LAWFUL USE CERTIFICATE

Reference:	H03-0880-23	Date of Decision:	22nd November 2023
Applicant:	Mr & Mrs Broderick 40 Haywain Drive Deeping St Nicholas Spalding Lincolnshire PE11 3TQ		
Location:	40 Haywain Drive Deeping St Nicholas Spalding		
Description:	Erection of single storey extension to dwelling

DRAWING NO
HW-PR-PL-02

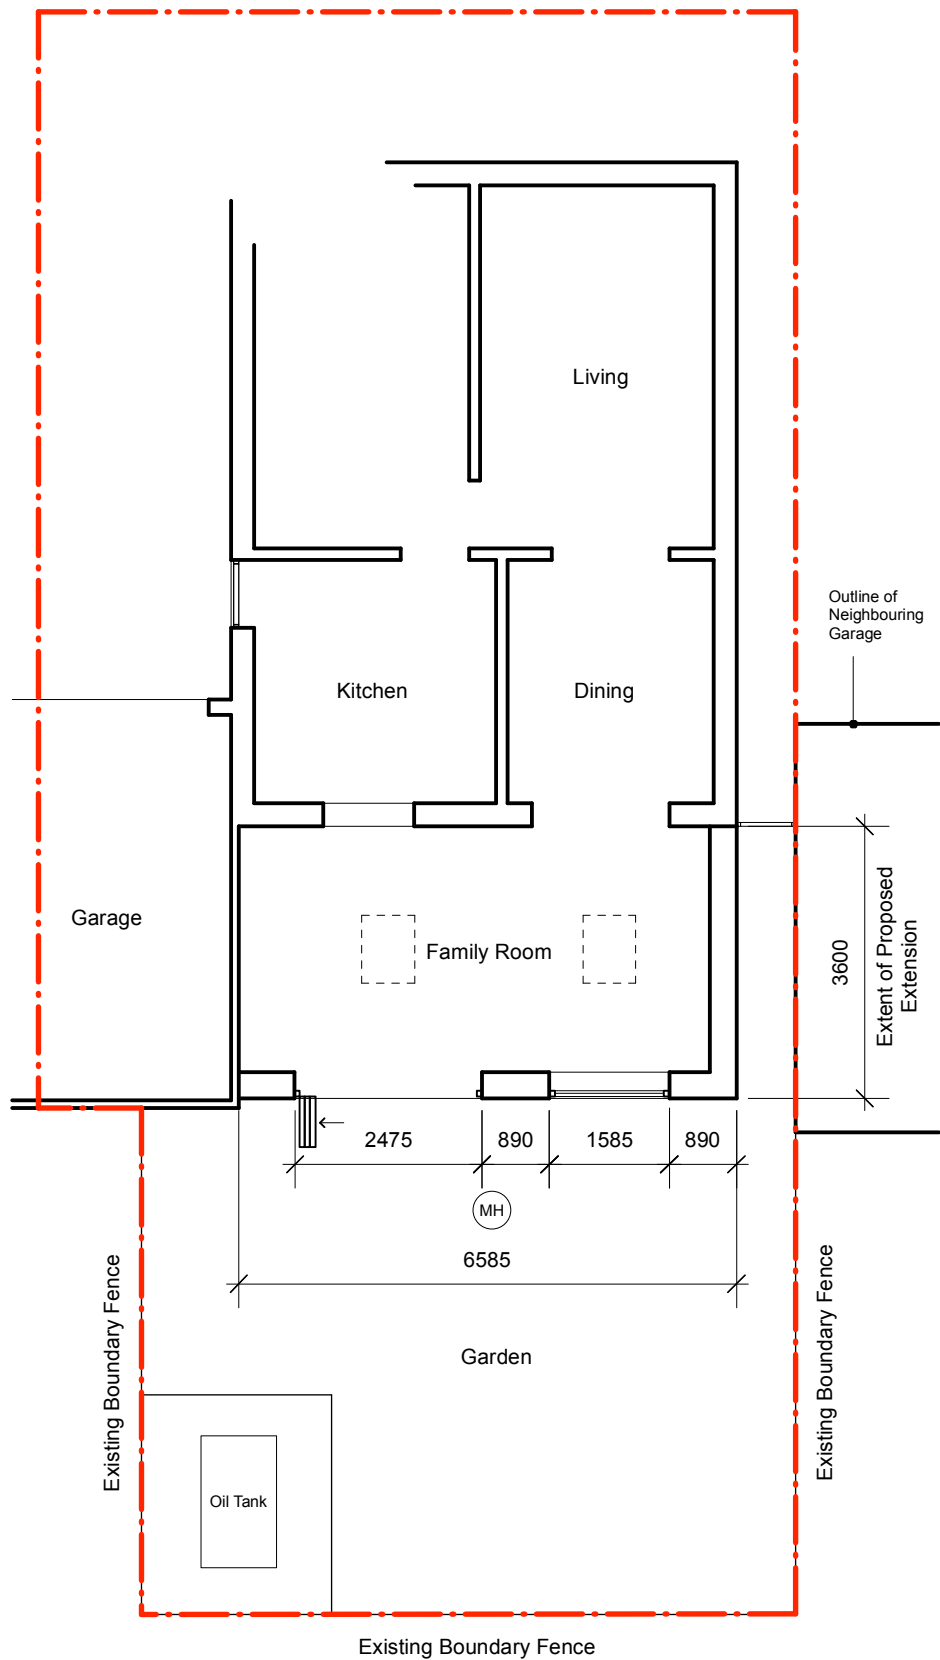
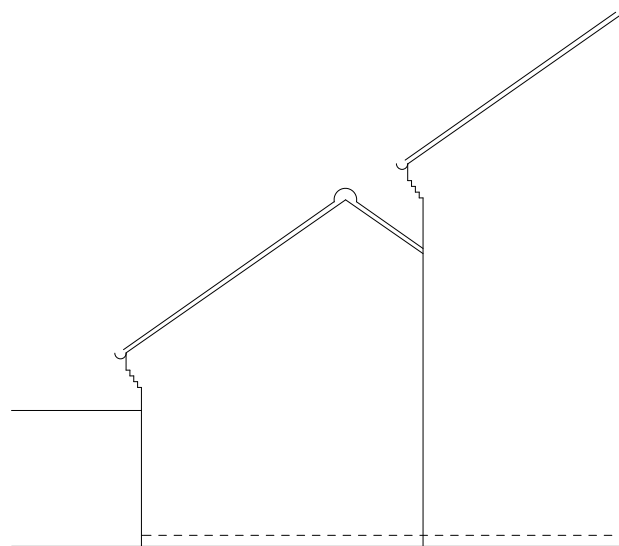
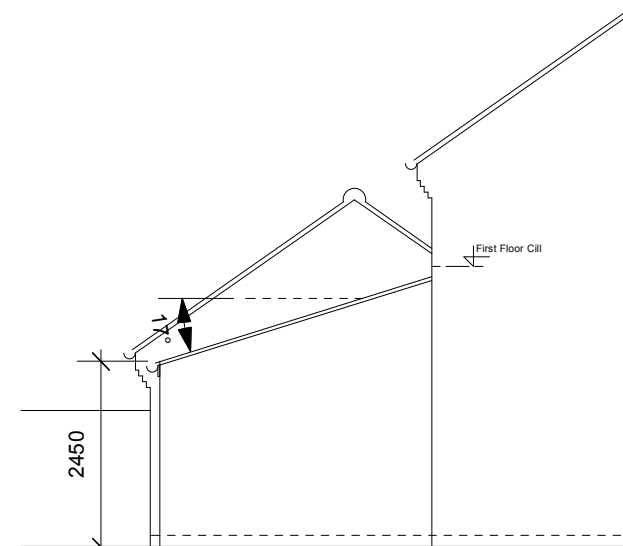
The proposed extension would comprise a side and rear extension. The proposed width of the extension would be greater than half the width of the original dwellinghouse. As such, a formal application for planning permission is required. The extension does not accord with Class A of Part 1 of Schedule 2 of the General Permitted Development Order (2015) (as amended).
